**Subject: Front Entry Plan Revisions  
126-128 Danforth Street  
Portland, Maine**

Attached please find drawings revisions to the front entry to 126 & 128 Danforth Street. Design incorporates granite cheek wall redesign from 2" thick veneer panels & granite caps to solid 16" thick granite cheek wall blocks and structural foundation design.

REHABILITATION OF FRONT ENTRY
126 & 128 DANFORTH STREET
PORTLAND, MAINE
PLAN AND DANFORTH STREET PARTIAL ELEVATION

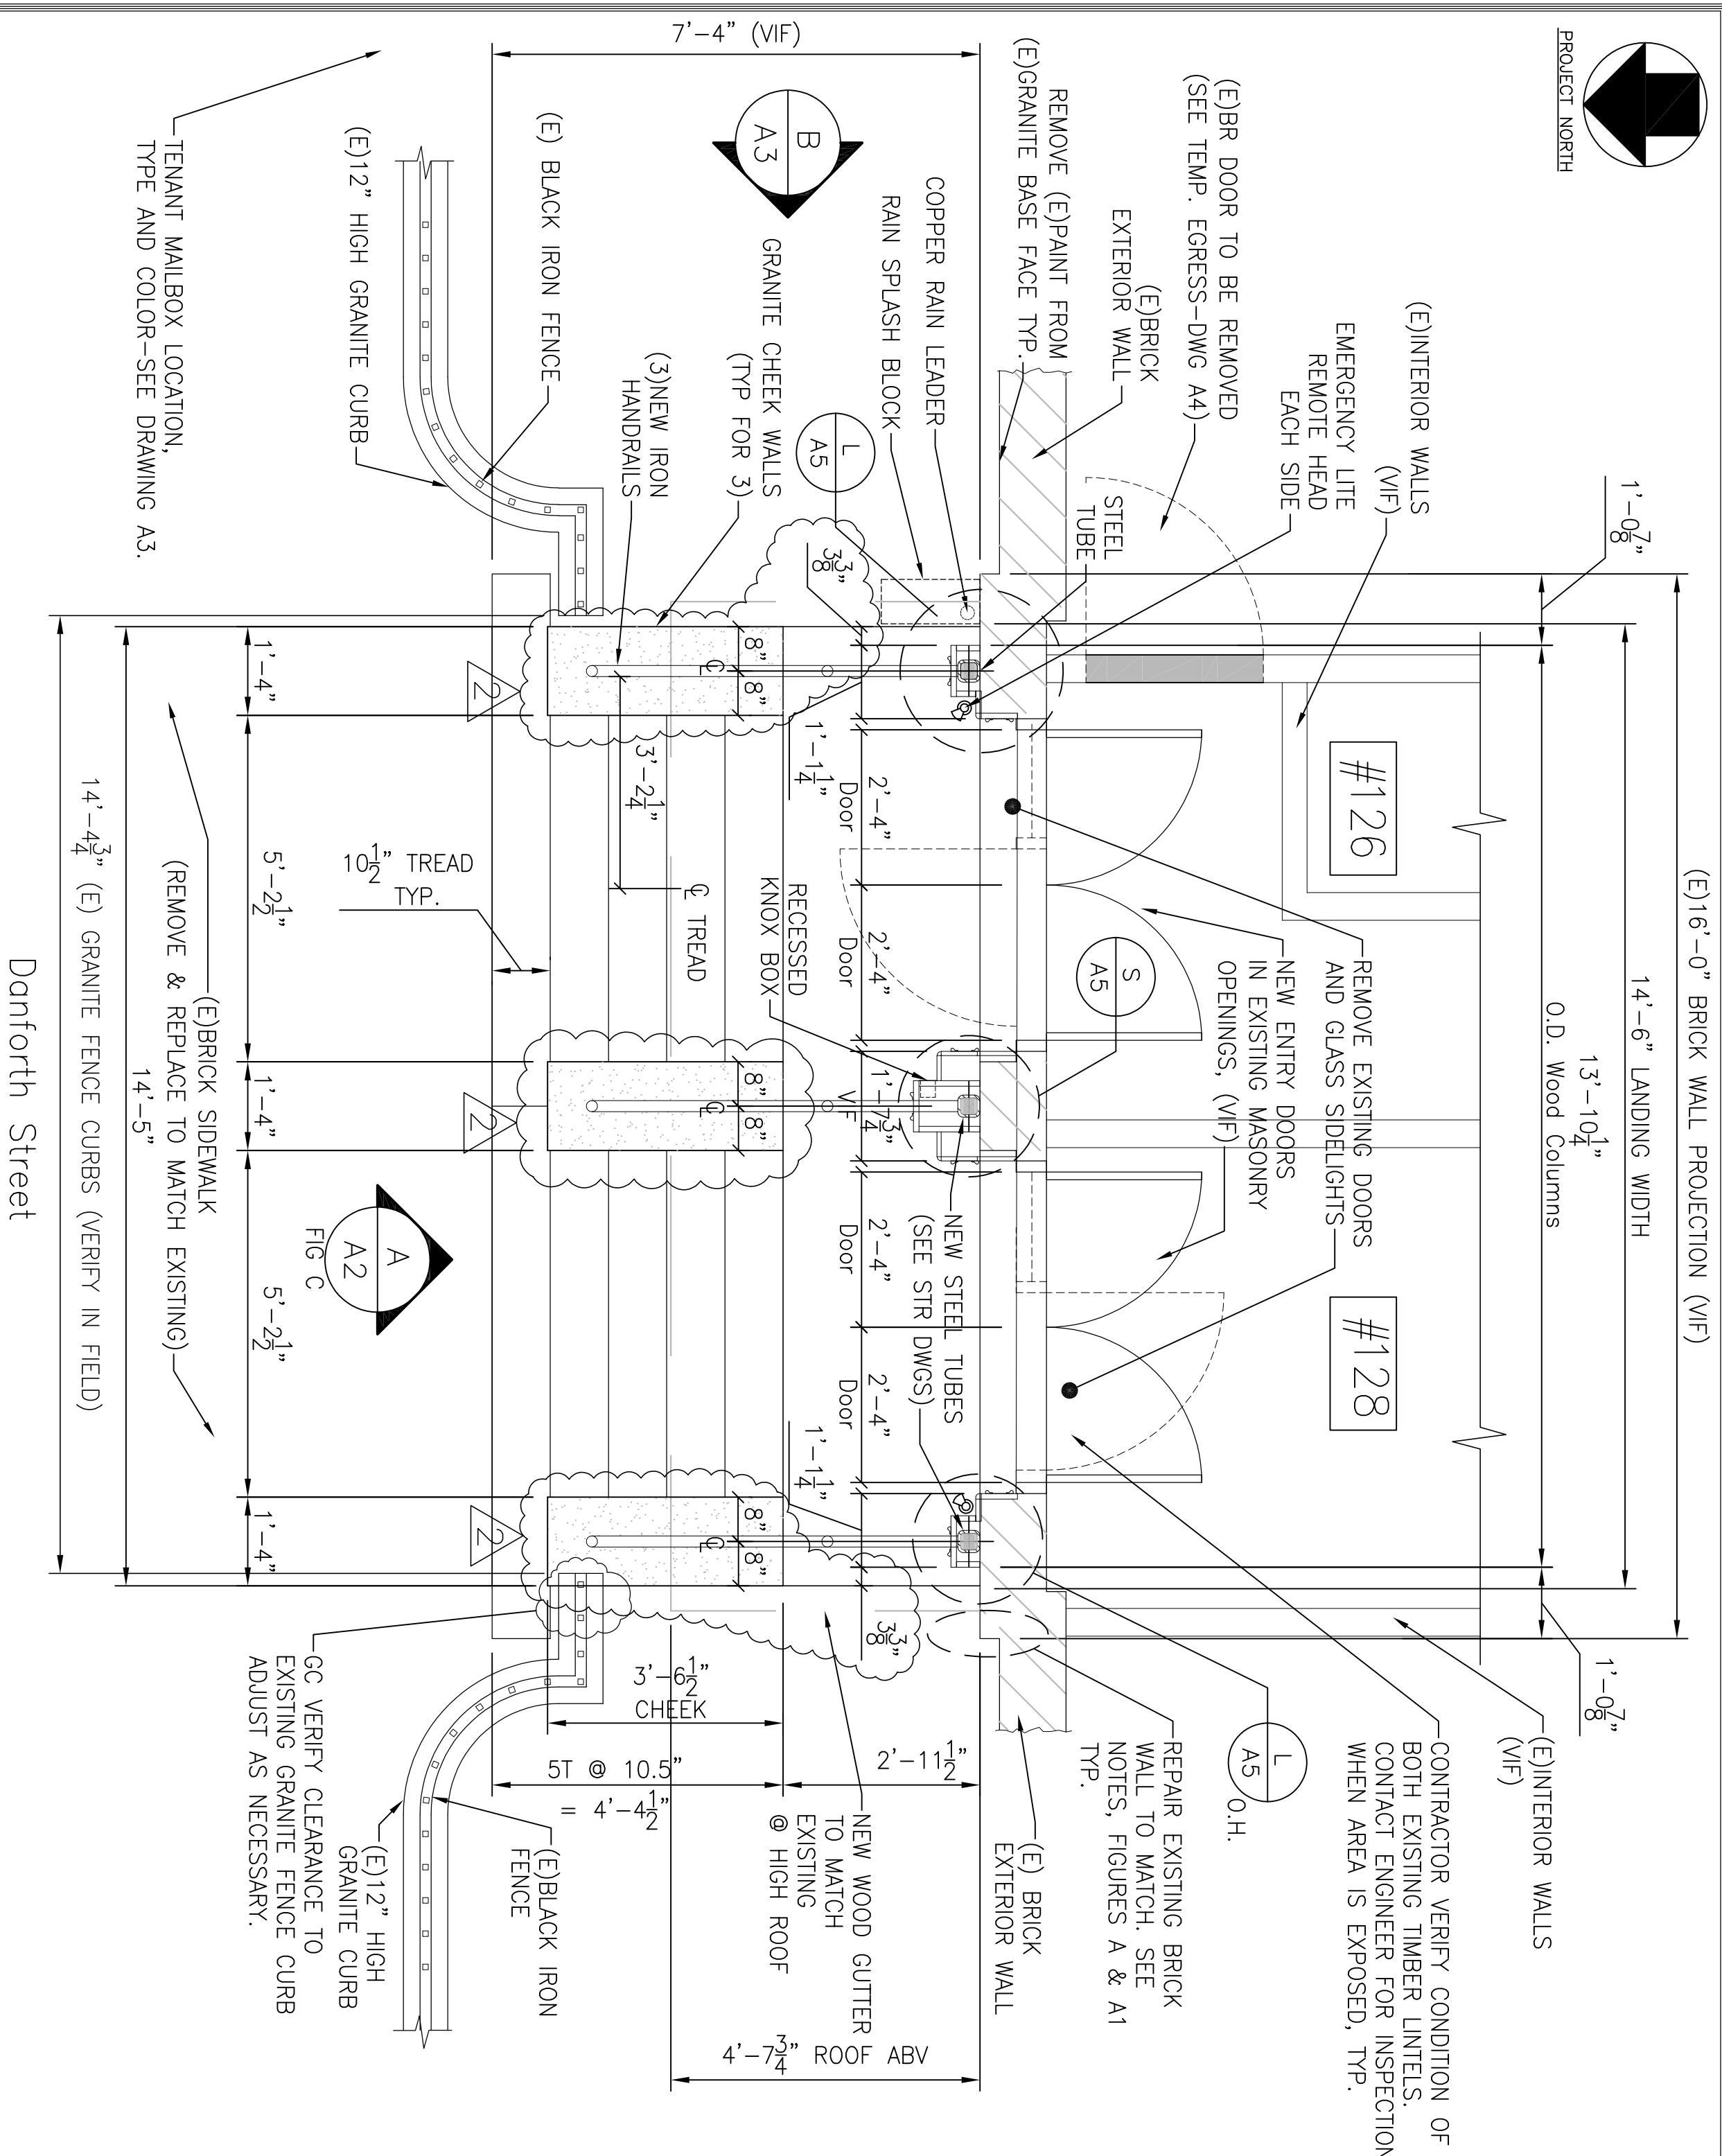
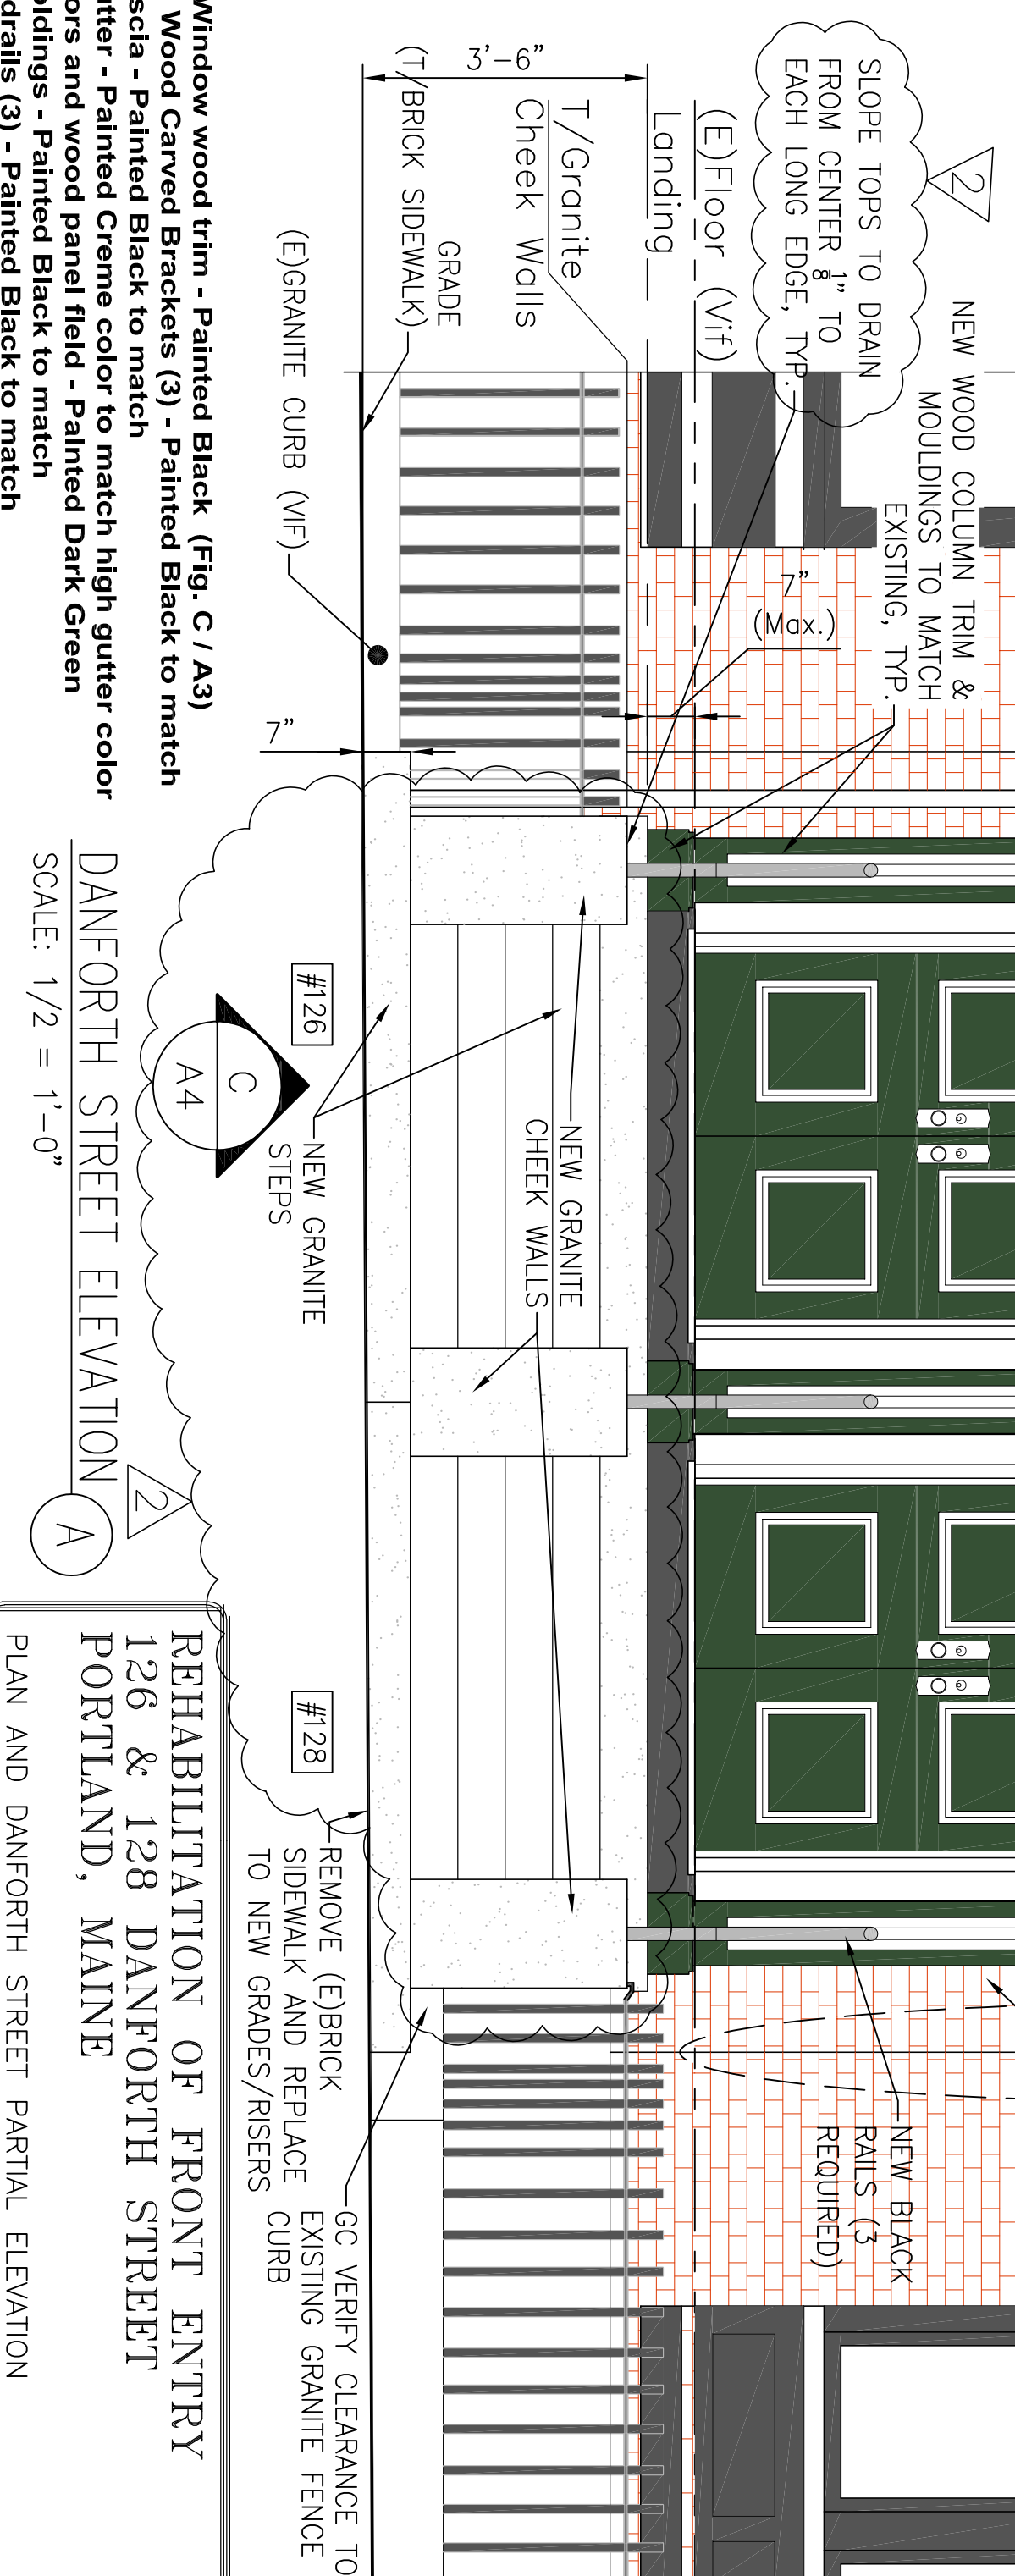
Drawings revised : **A2, A3, A5 and S1, S2, S3 and S5**
